From: Biazar, Shahab
Sent: Friday, November 08, 2013 8:48 AM
To: 'Trula Howe'
Subject: RE: Confirm

SANTA FE FEDERAL CREDIT UNION
GRADING AND DRAINAGE PLAN
ALBUQUERQUE, NEW MEXICO

July 3, 2013

Re: Santa Fe Federal Credit Union, 7101 Jefferson Street NE, Grading and Drainage Plan, Engineer's Stamp dated 06-04-2013 (D-17/D017)

Flowline?

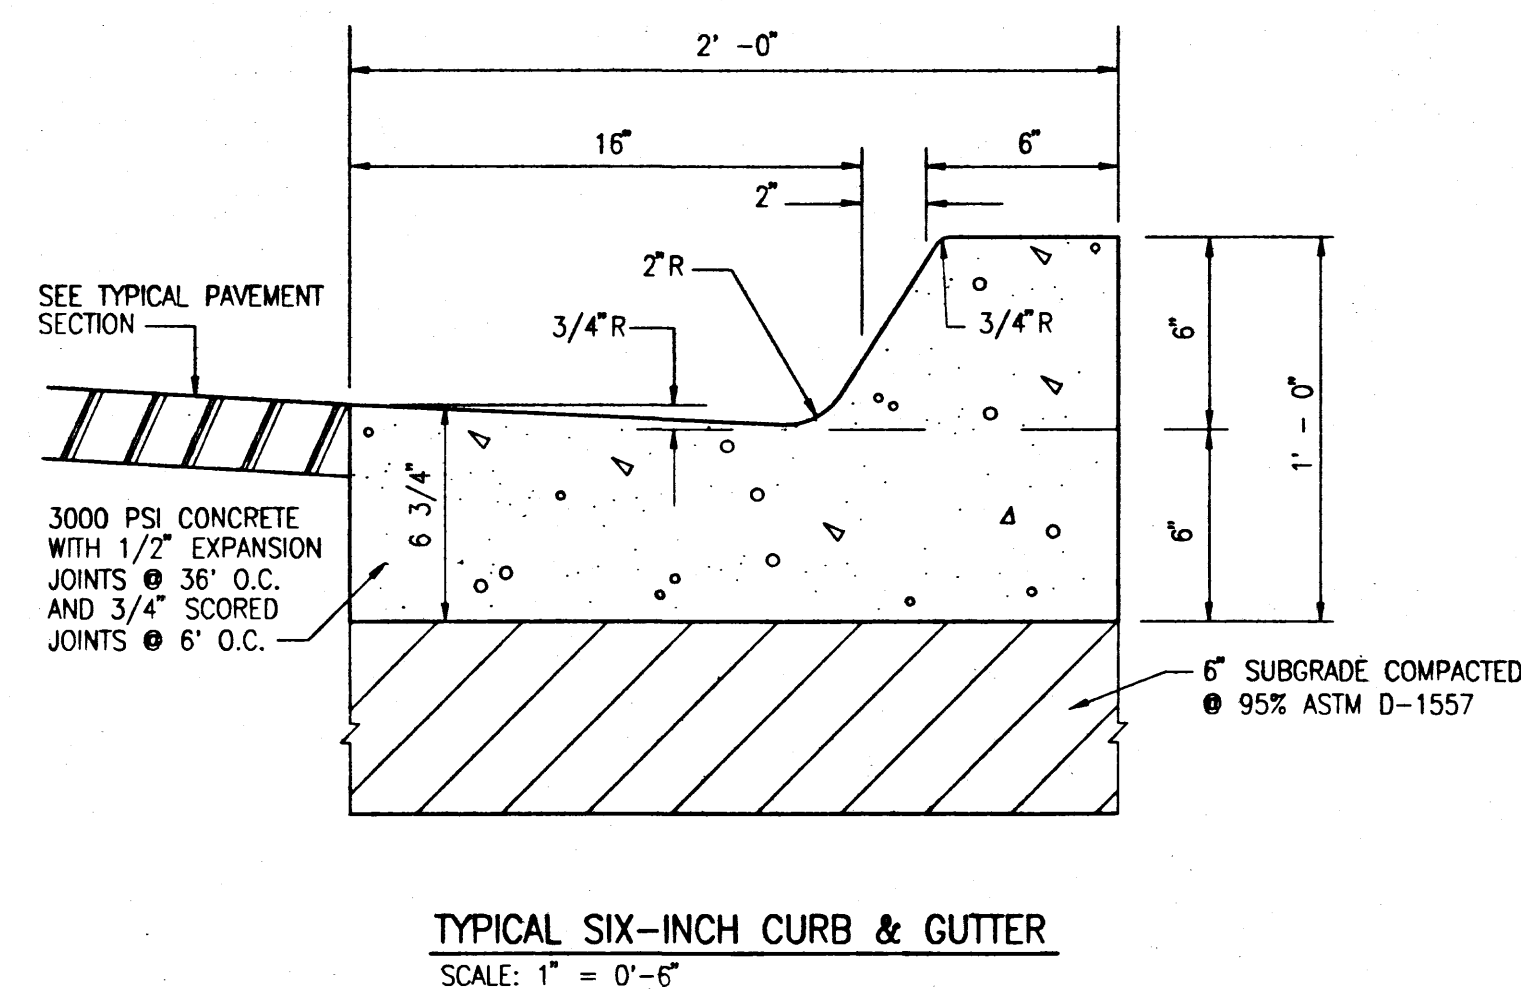
- Please quantify the offsite flows from the parking lot to the north of your project and include these flows in the drainage calculations for the existing sidewalk culvert; if over capacity address how these flows will be accommodated.
- Add a note to extend the culvert and culvert plate two feet back from the property line and to tack weld the bolts to the steel plate.
- Clarify if the existing swale is completely asphalt lined. Satellite imagery shows a significant amount of sediment in this channel.
- If the sidewalk culvert is altered please provide both an invert elevation and flowline elevations within Ellison Street.
